Royal Prince Alfred Hospital North West Precinct Redevelopment

SECTION 75W APPLICATION

Architectural Design Statement

Document Reference: 3599-0603-012

DEPARTMENT OF PLANNING SUBMISSION
SITE PLAN

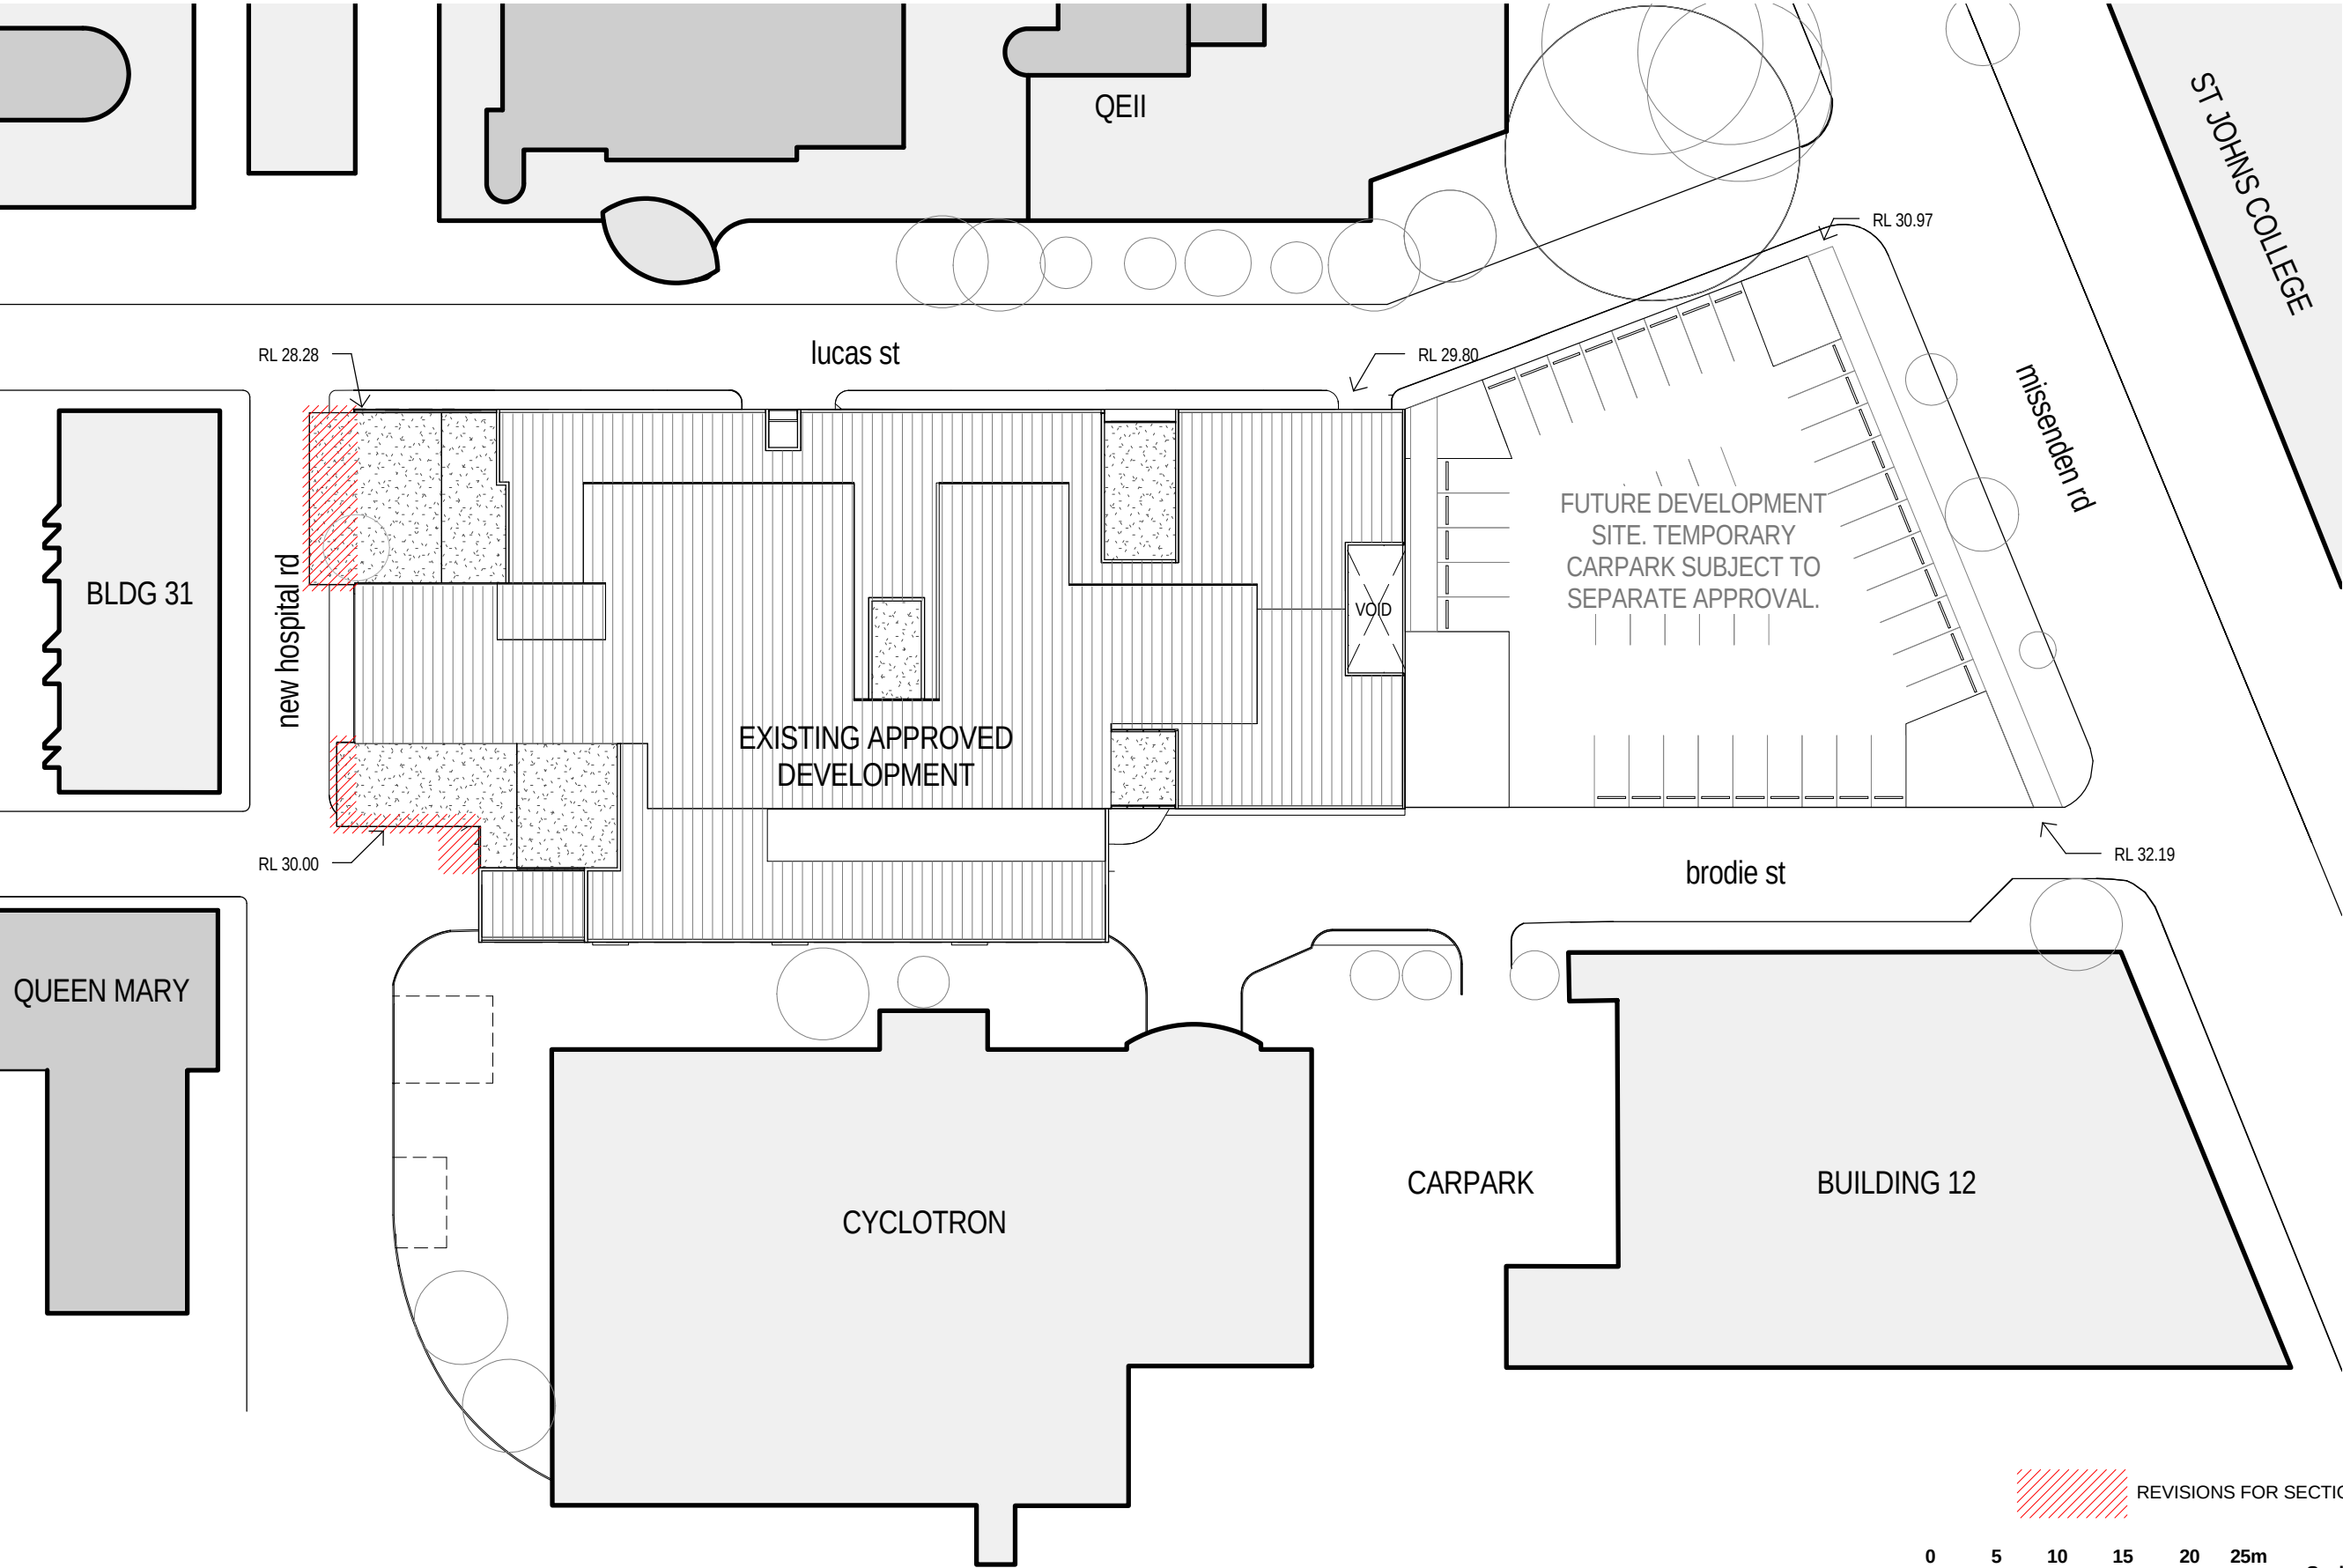
Drawing	Title	Revision	Comment/updated item
DoP-050	Site Plan	3	Courtyard extensions to Levels 3 and 4.
DoP-100	Ground Level Plan	3	Ground level entry and vehicle drop off revised. DDA ramp removed, platform lift shown. Entry to the Mental Health Assessment Unit and Short Stay Units has been revised to eliminate the ramp on Brodie Street.
DoP-101	Level 1 Plan	3	Façade line altered in line with ground level changes.
DoP-103	Level 3 Plan	3	Increase to Level 3 courtyard.
DoP-104	Level 4 Plan	3	Increase to Level 4 Female HDU courtyard.
DoP-200	Elevation – Sheet 1	3	Minor changes to ground and level 1 glazing at entry and vehicle drop-off. Courtyard cantilever to Level 3.
DoP-201	Elevation – Sheet 2	3	Courtyard cantilever to Level 4. Revised MHAU and Short Stay unit entrance. Building configuration and extent within the entry and vehicle drop-off.
DoP-202	Elevation – Sheet 3	3	Increased extent of terracade cladding on the western façade to conceal mechanical ductwork.

DEPARTMENT OF PLANNING SUBMISSION
GROUND LEVEL PLAN
ROYAL PRINCE ALFRED HOSPITAL
North West Precinct Project, Camperdown

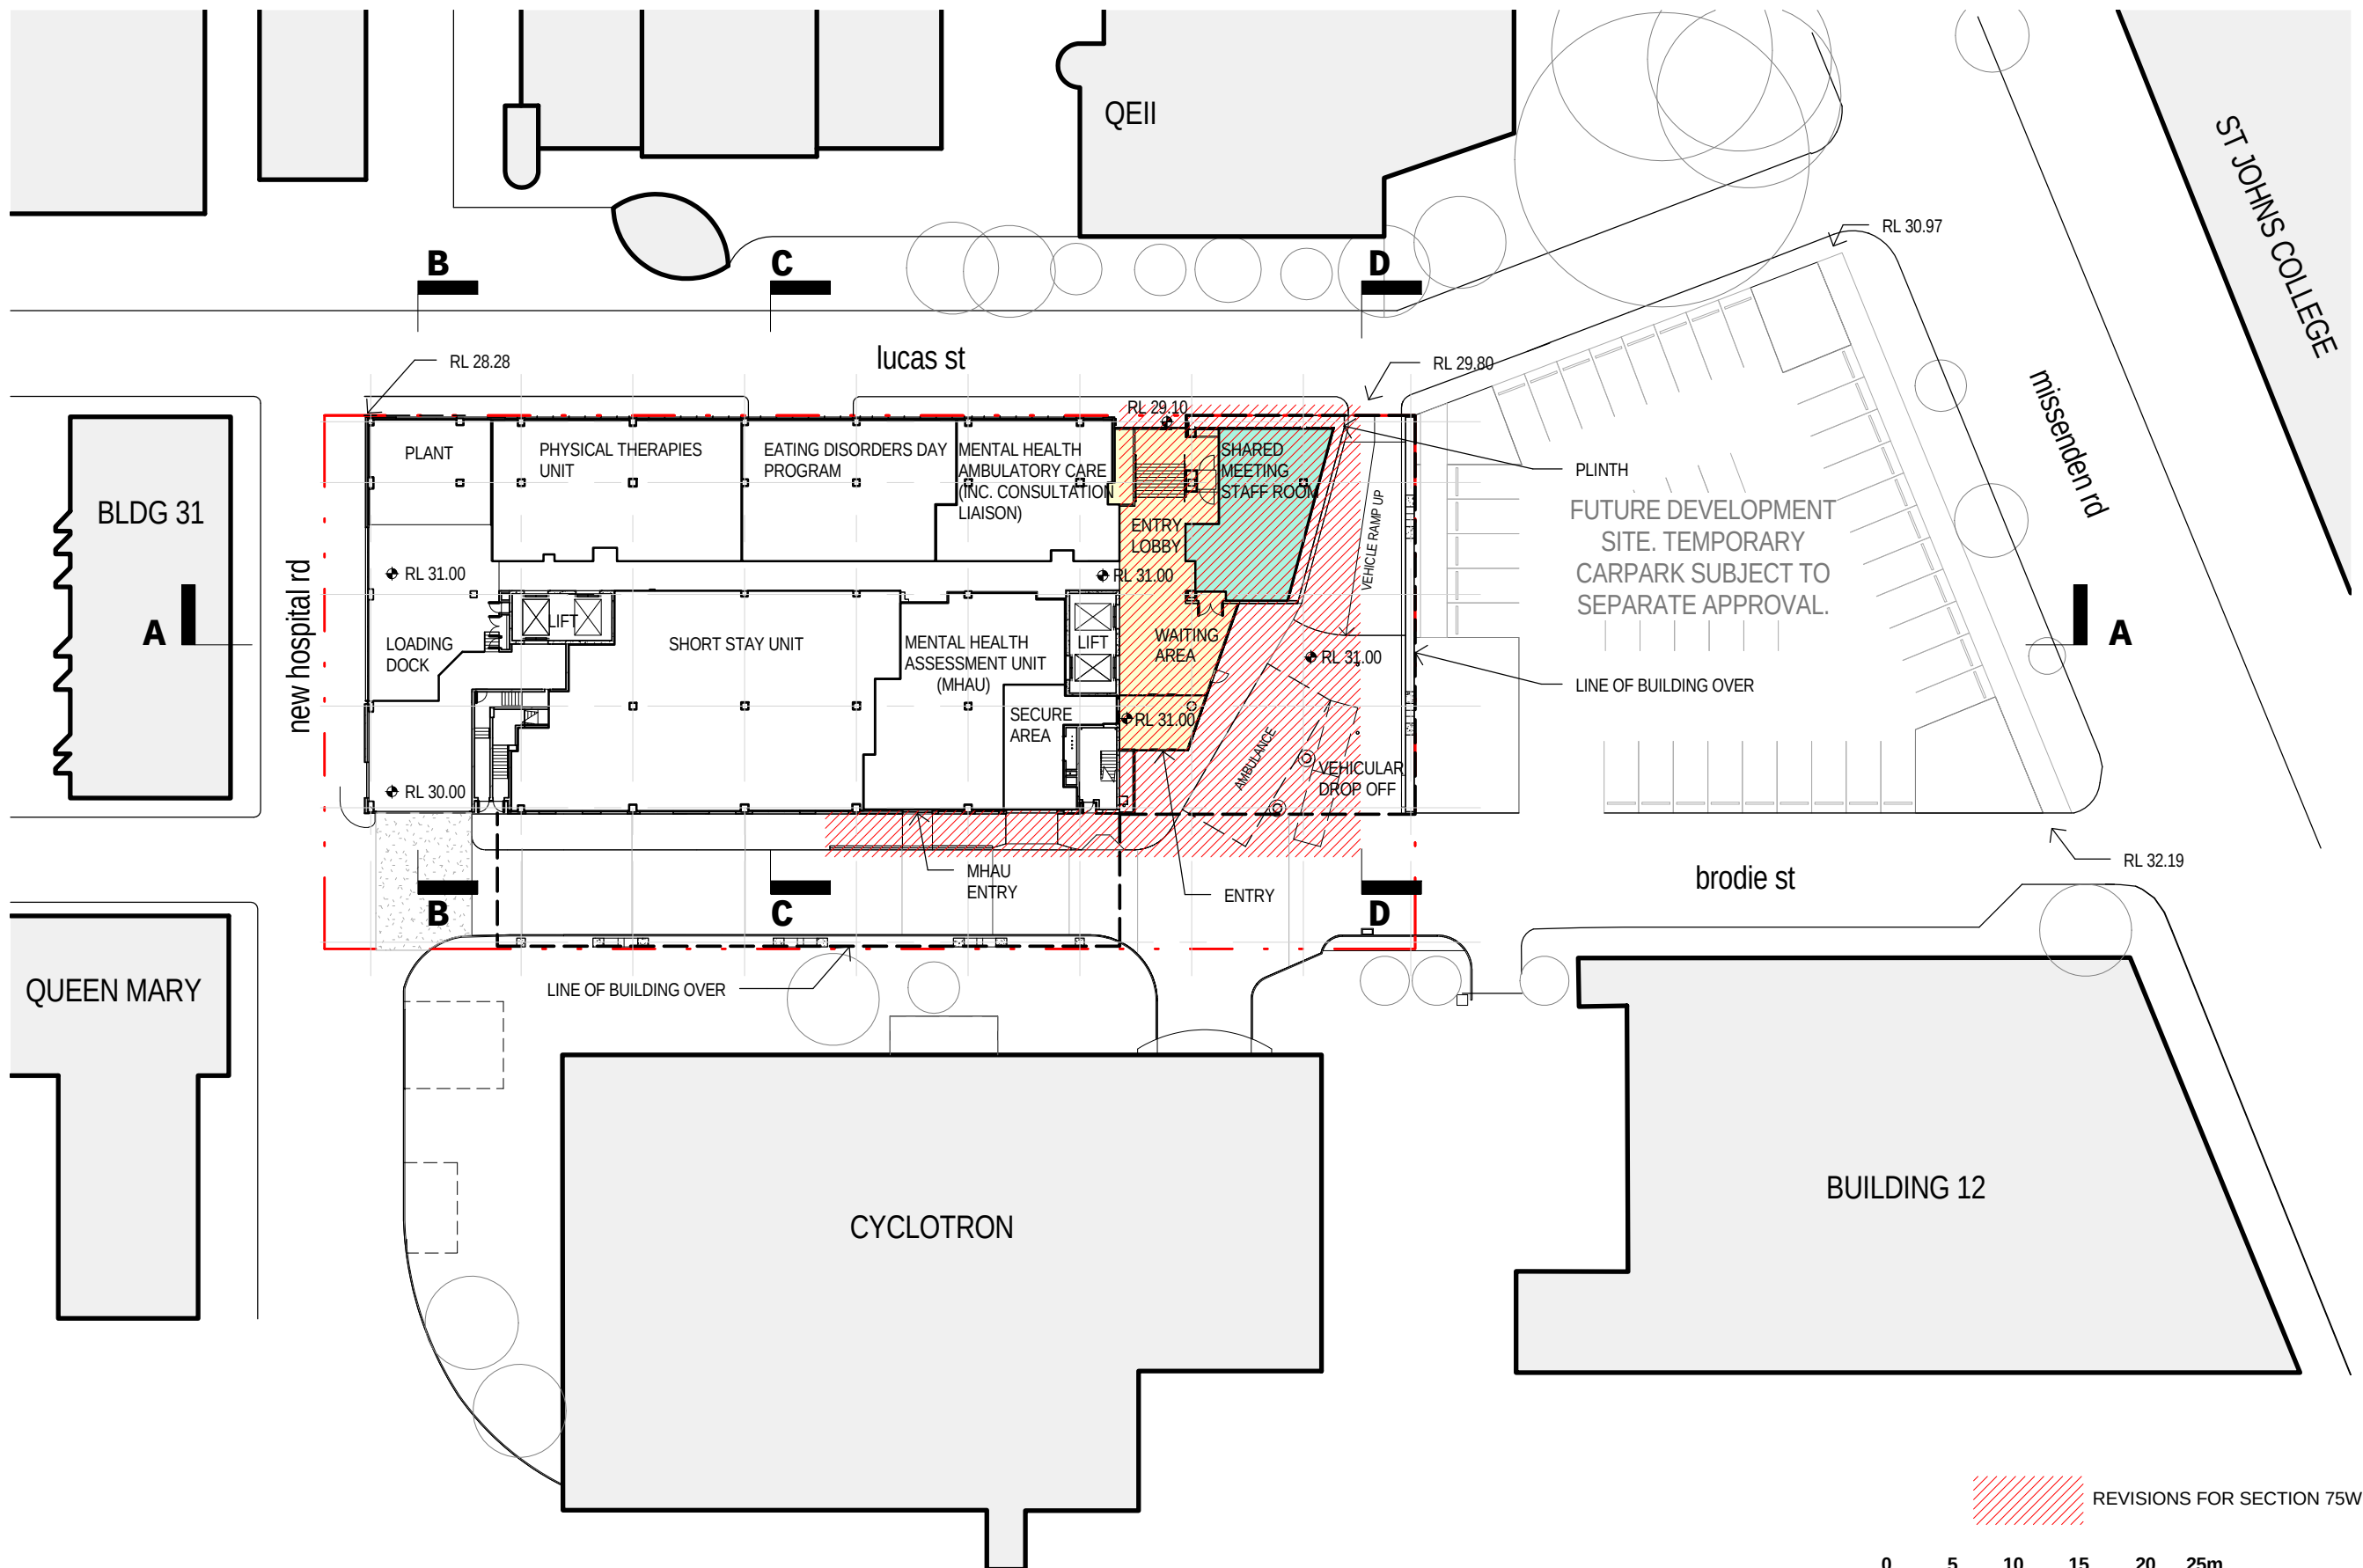
3.0 GROUND LEVEL – BUILDING ENTRY AND VEHICLE DROP-OFF

As part of design development, the disabled access ramp from Lucas Street was reconsidered in consultation with the DDA consultant and substituted for a disabled platform lift at the Lucas Street entry. This solution was considered for the following reasons:

- The setdown and structural profile of the disabled ramp had a significant impact on height clearances at the lower ground level, limiting vehicular movement and the use of the north-east corner of the car park;
- To create a centralised Lucas Street entrance for all visitors, patients and staff, regardless of their level of mobility;
- To separate pedestrian movement from the vehicular access ramp and entry;
- To provide a more efficient configuration of the vehicle drop off area, in particular increasing the proportion of the off-loading area and entry of patients from the ambulance/patient transport vehicles; and
- A rationalisation of access to the building, promoting a through link between Brodie Street and Lucas Street.
